CITY OF ALBUQUERQUE

**Re: Winrock Redevelopment Section 2 and Section 4 Grading and Drainage Plan
Engineer's Stamp Date 7-20-15
Drainage file number (J19D058C)**

DATE: 07/14/15	sheet- 1
SCALE: 1"=100'	C100 of- 13

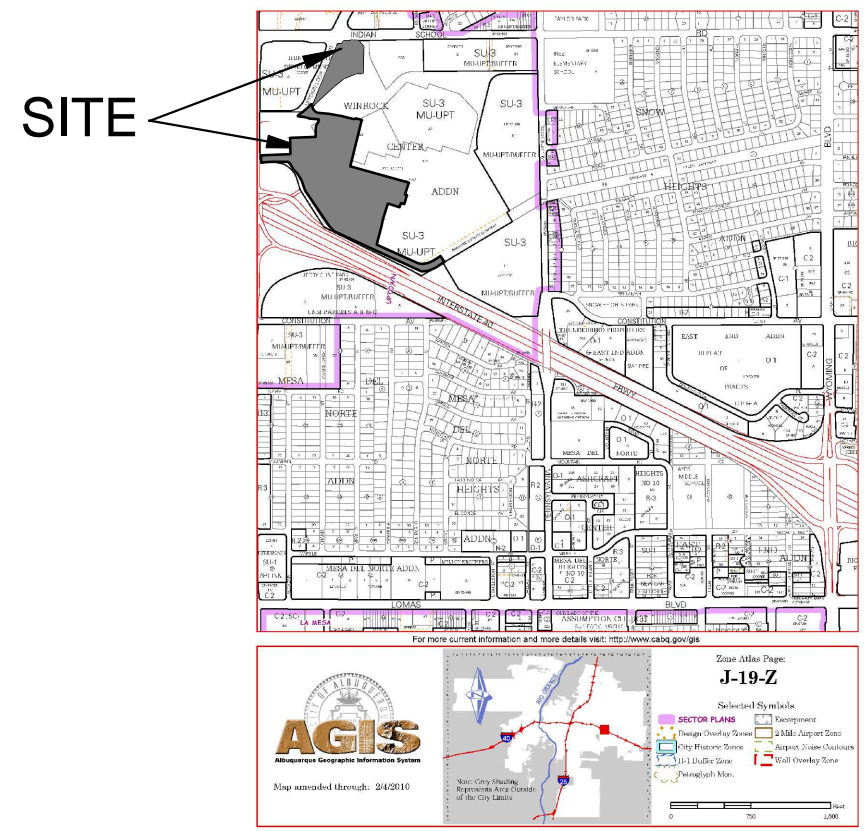
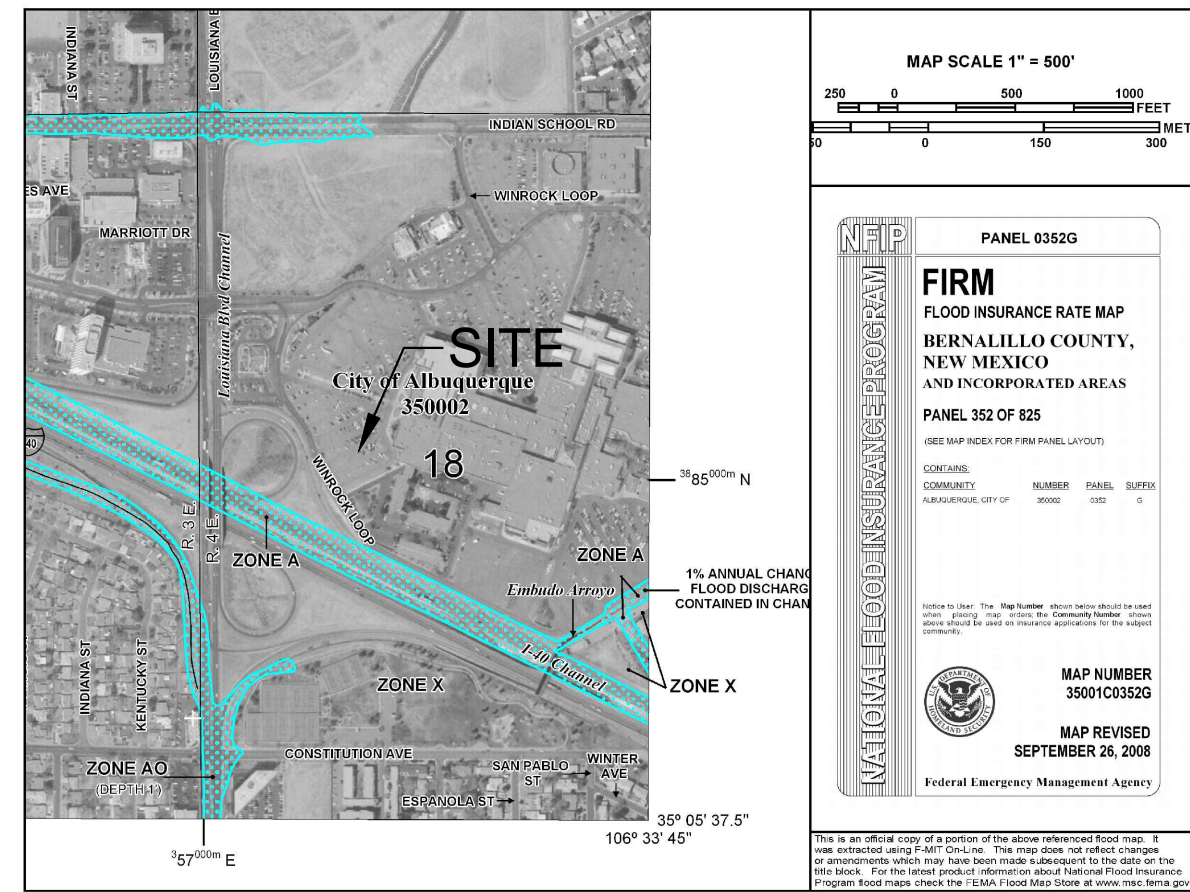
1. Storm drain sizes as shown on Sheet C103 should be included in the Work Order, not C100 and C102, for the outfall to the 84" existing storm drain.
2. The narrative states that rooftop basins will be directed to the water feature for treatment. This should be revised to state that the first flush from rooftops will be treated by an underground retention system in the interim condition.

DATE 07/20/15	SHEET 2
SCALE 1"=100'	<b>C101</b>

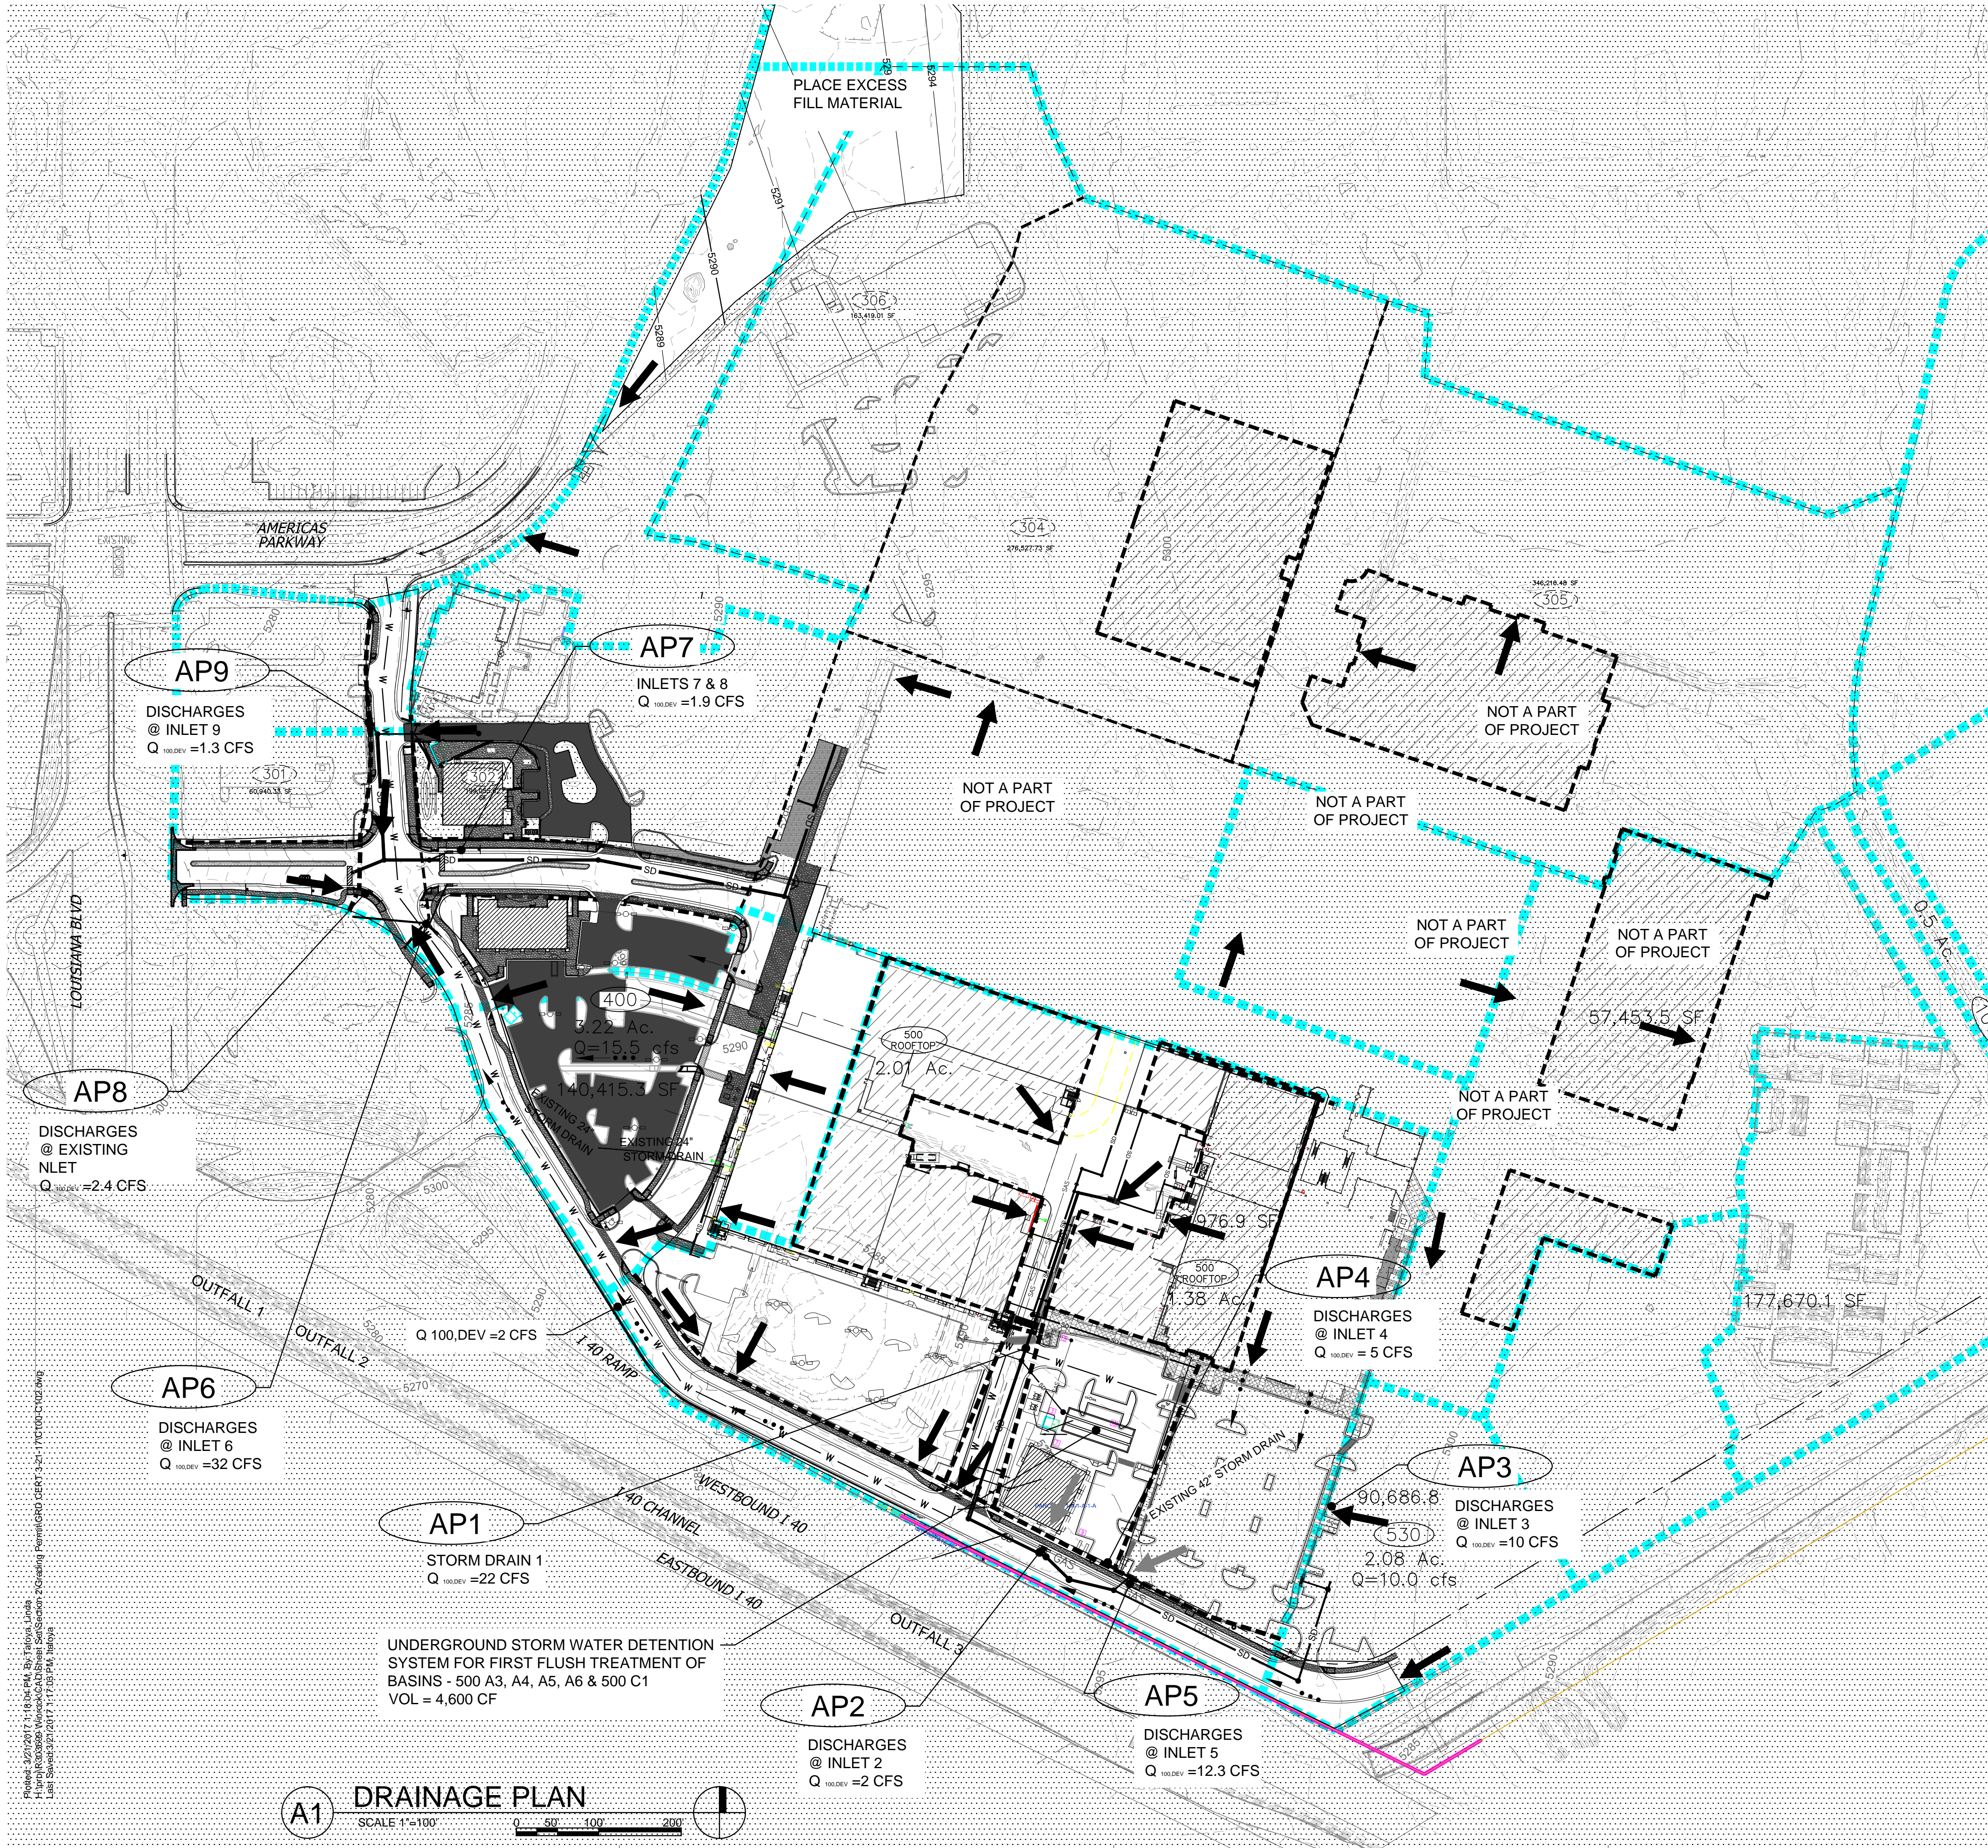
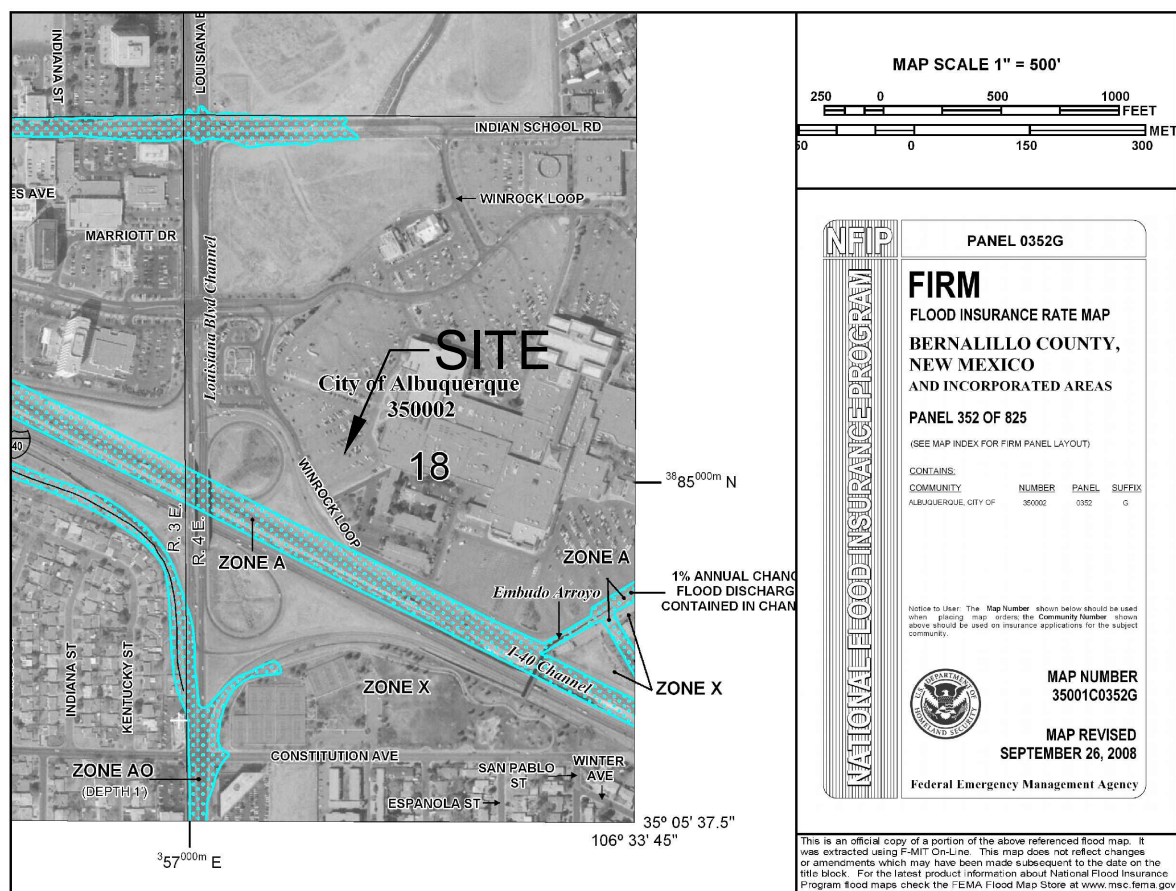
11. As a note for future submittals, the manning's coefficient for streets is 0.017, not 0.013. The street had excess capacity using 0.013, so it should work if 0.017 was used.
12. On Sheet C101, correct the flows on Basins 302-A1 and 302-A2 to 2.8 cfs and 4.2 cfs, respectively.

INLET 6

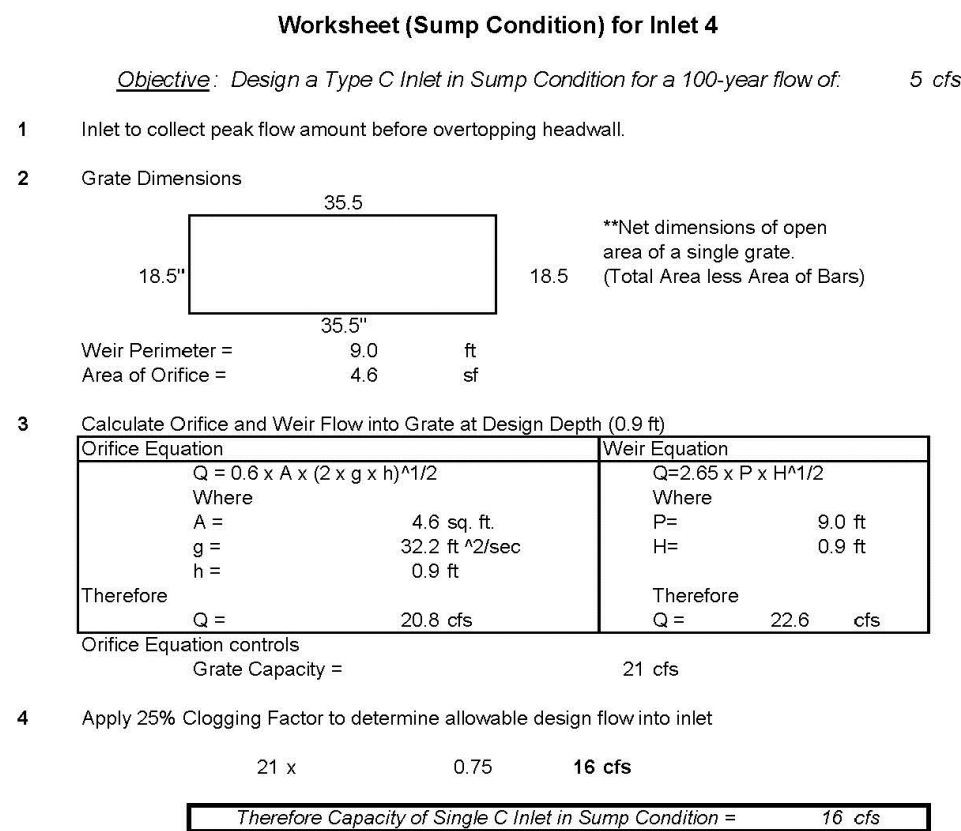
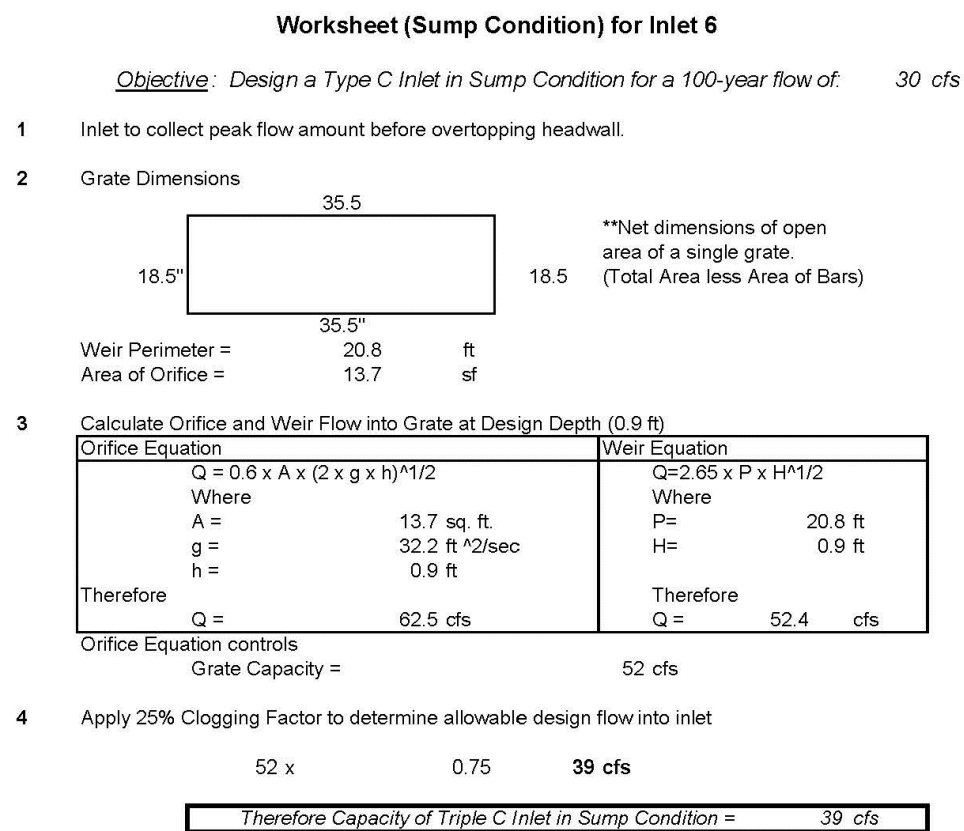
3. Inlet 6 is proposed as a Triple "C" inlet. However, the City does not have a standard drawing for a Triple "C" inlet so a Double "C" inlet with a connector pipe to an "A" inlet may work. This can be addressed on the Work Order plans.
